**WELWYN HATFIELD BOROUGH COUNCIL
EXECUTIVE DIRECTOR - PLANNING, PUBLIC PROTECTION AND GOVERNANCE**

Application No: 6/2022/0637/PN8
Location: Coverack 50 The Ridgeway Cuffley Potters Bar EN6 4BA
Proposal: Prior approval for an 8m rear extension from the kitchen and dining room to form a family room measuring 8 metres in depth and 3 metres to the eaves
Officer: Mrs Kerrie Charles

Recommendation: Refused

Site address	50 The Ridgeway Cuffley EN6 4BA
Project Description	Rear Extension
Drawing Title	Existing Floor Plans & Elevations
Drawn	AA
Checked by	DP
Issued for	Planning Approval
Scale	1:100@A1
Drawing No.	1569_310
Date	March 2022

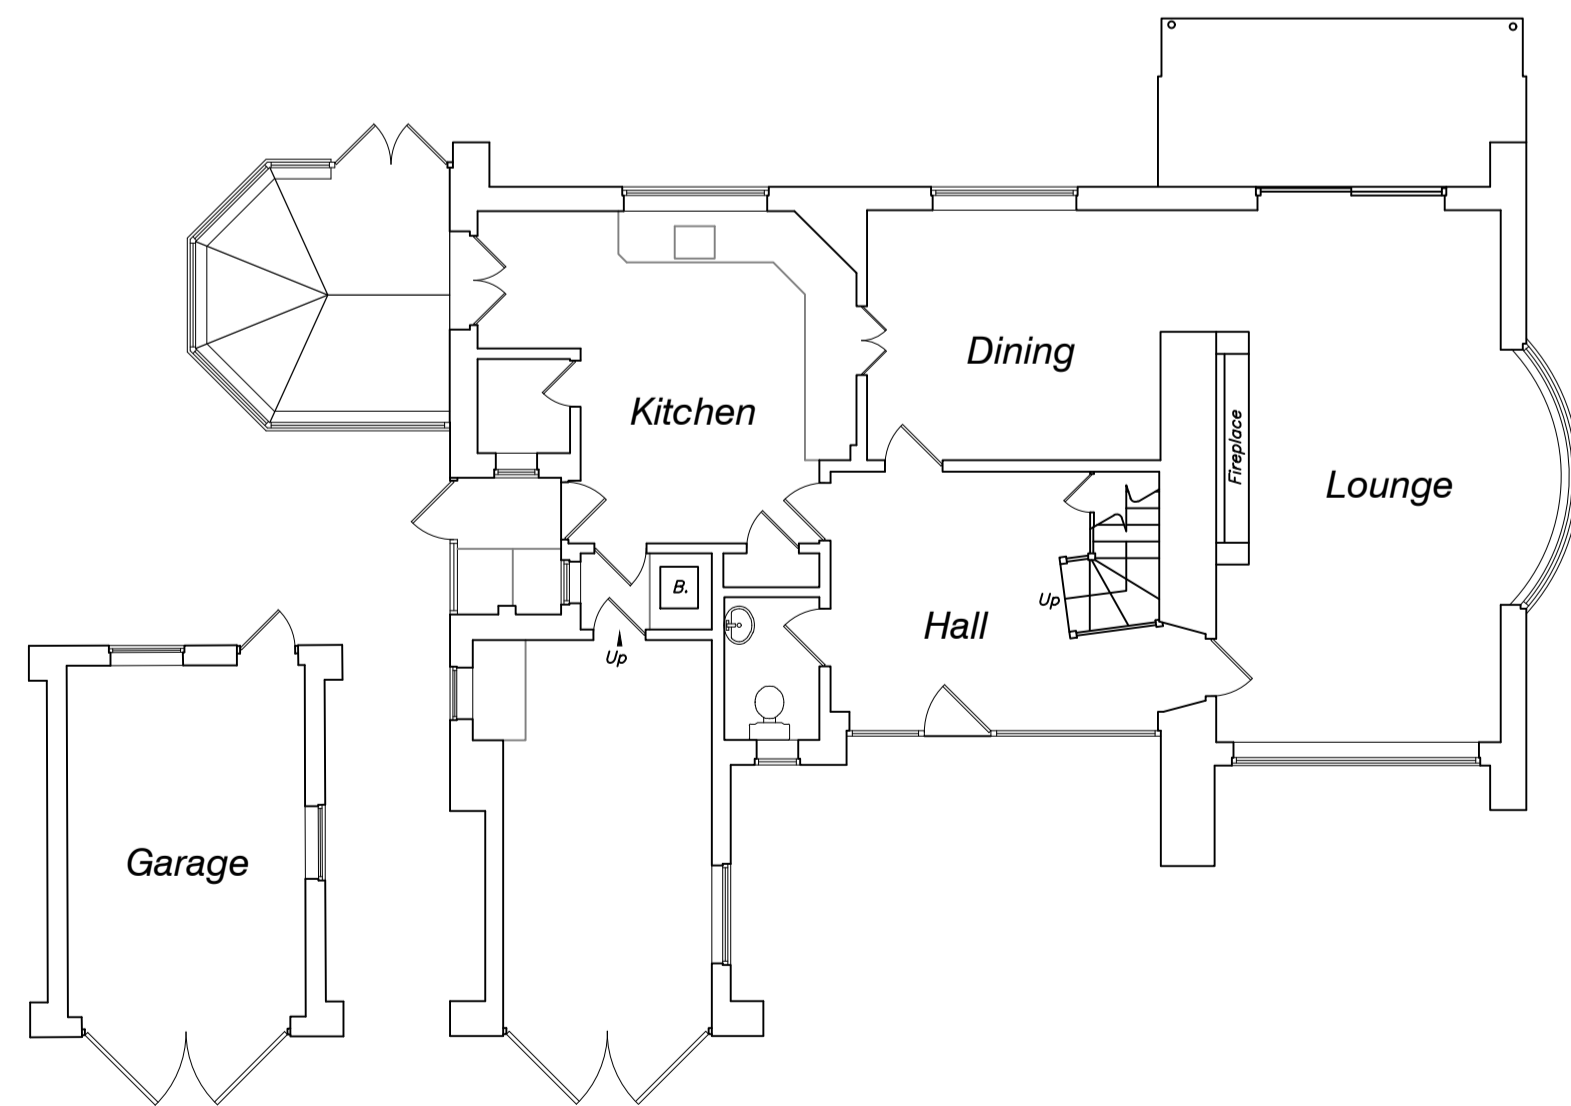
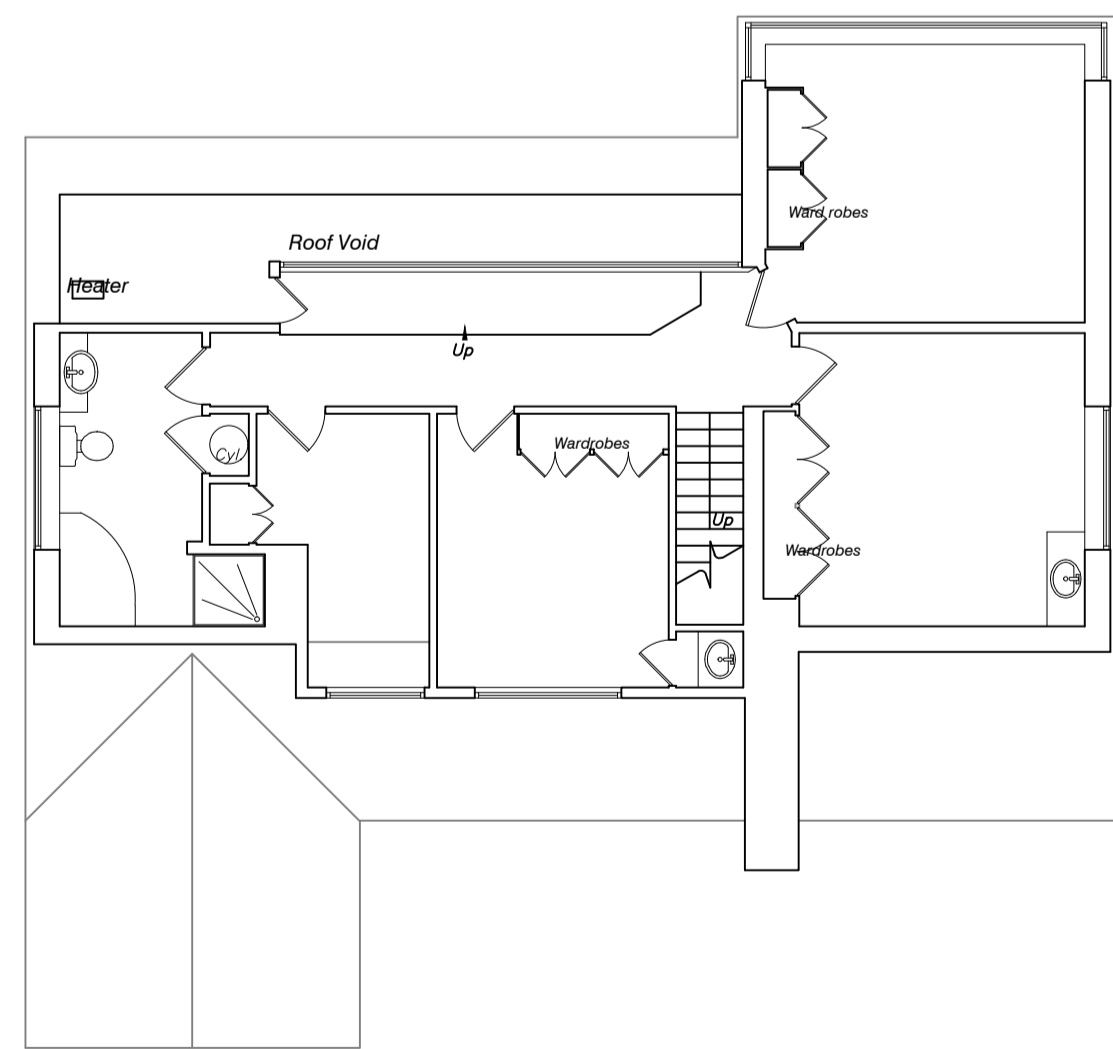
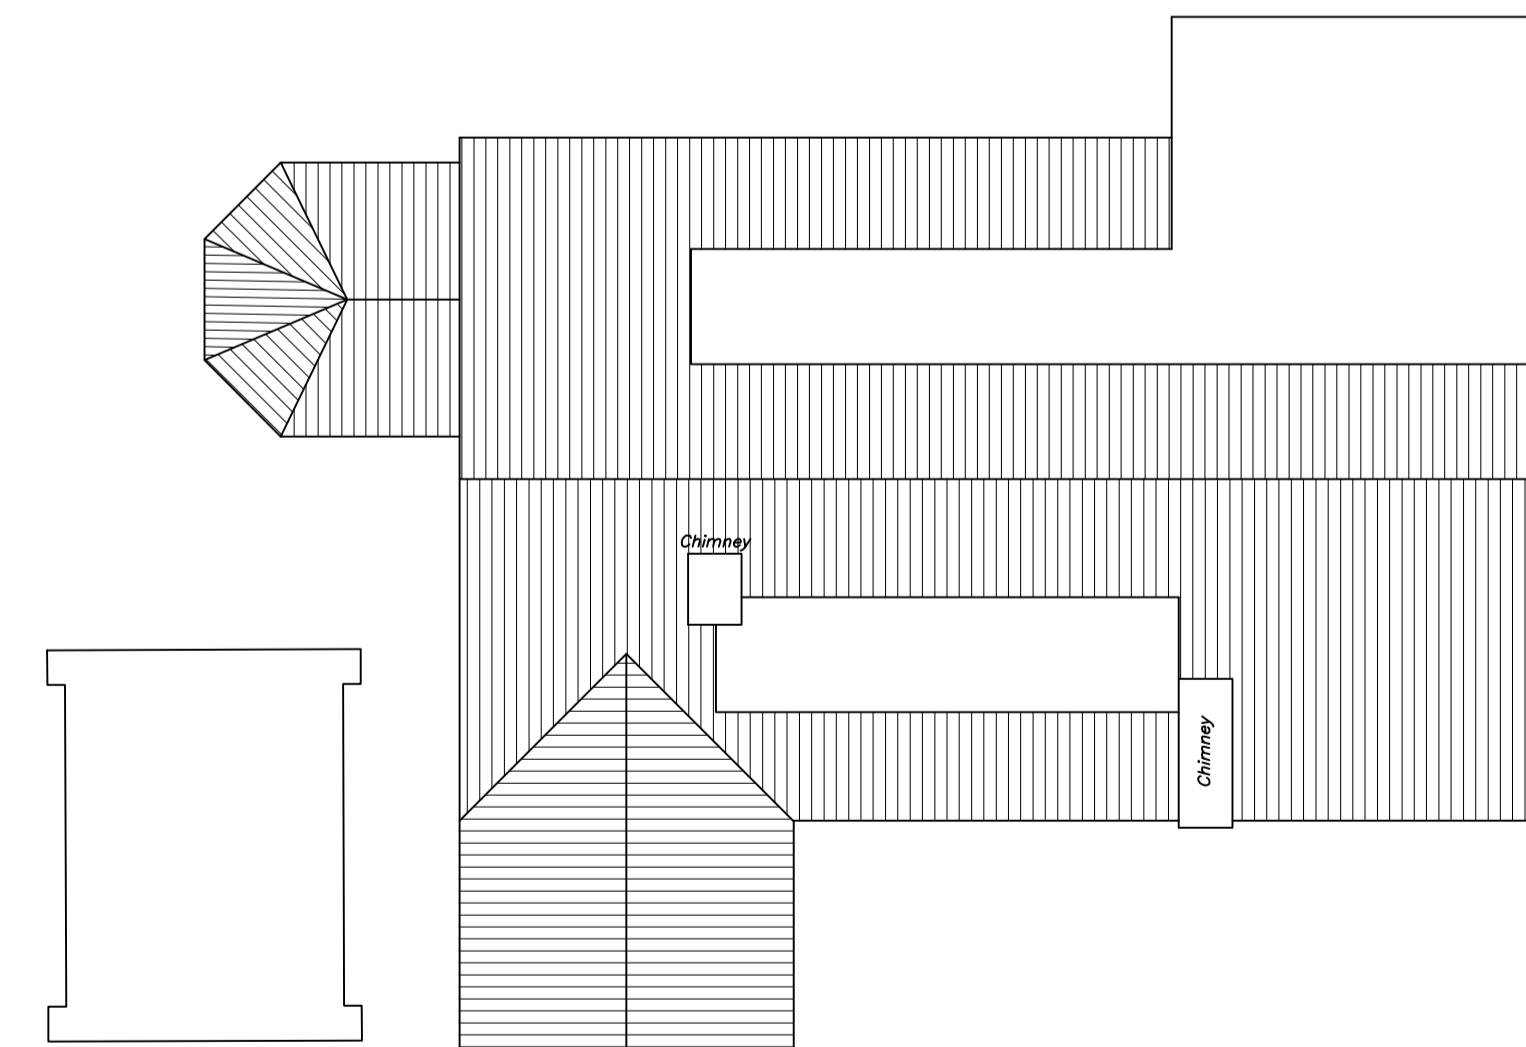
(g) is the development outside of article 2(3) land (conservation area) or outside of a site of special scientific interest	Y	Y
(g) cont_ would it have a single storey (previous extensions to the rear need to be taken into account)	N - when joined to the existing first floor/roof extension

(i) Would it extend beyond the rear wall of the original dwellinghouse by up to or the equivalent of 8 metres in the case of a detached dwellinghouse, or 6 metres in the case of any other dwellinghouse	Y - 8m	Y
(ii) Be less than or equal to 4 metres in height	N - when joined to the existing first floor/roof extension	Y
Have any representations been received from adjoining premises	Y - Supporting the development

(h) would the enlarged part of the dwellinghouse have more than one storey and:- (i) extend beyond the rear wall of the original dwellinghouse by more than 3 metres, or (ii) be within 7 metres of any boundary of the curtilage of the dwellinghouse being enlarged which is opposite the rear wall of that dwellinghouse;	Y - when joined to the existing first floor/roof extension	N

(j) would the enlarged part of the dwellinghouse extend beyond a wall forming a side elevation of the original dwellinghouse, and:- (i) exceed 4 metres in height, (ii) have more than one storey, or (iii) have a width greater than half the width of the original	Y	N

dwellinghouse		
(ja) any total enlargement (being the enlarged part together with any existing enlargement of the original dwellinghouse to which it will be joined) exceeds or would exceed the limits set out in sub-paragraphs (e) to (j)	Y	N

1. The proposed works is NOT permitted development by virtue of Schedule 2, Part 1, Class A of the Town and Country Planning (General Permitted Development) (England) Order 2015 as amended. The proposed extension would extend a first floor extension and would extend beyond a wall forming a side elevation, therefore fails to meet the requirements set under paragraphs A.1(f) and A.1(g) set out the limitations for single-storey extensions beyond the rear wall of the original dwelling/house and paragraph A.1(j) sets out the limitations for extensions beyond a wall forming a side elevation of the original dwelling/house. As the extension would have a width greater than half the width of

the original dwelling/house it would exceed the limitation on the width set out in clause (iii) of paragraph A.1(j).
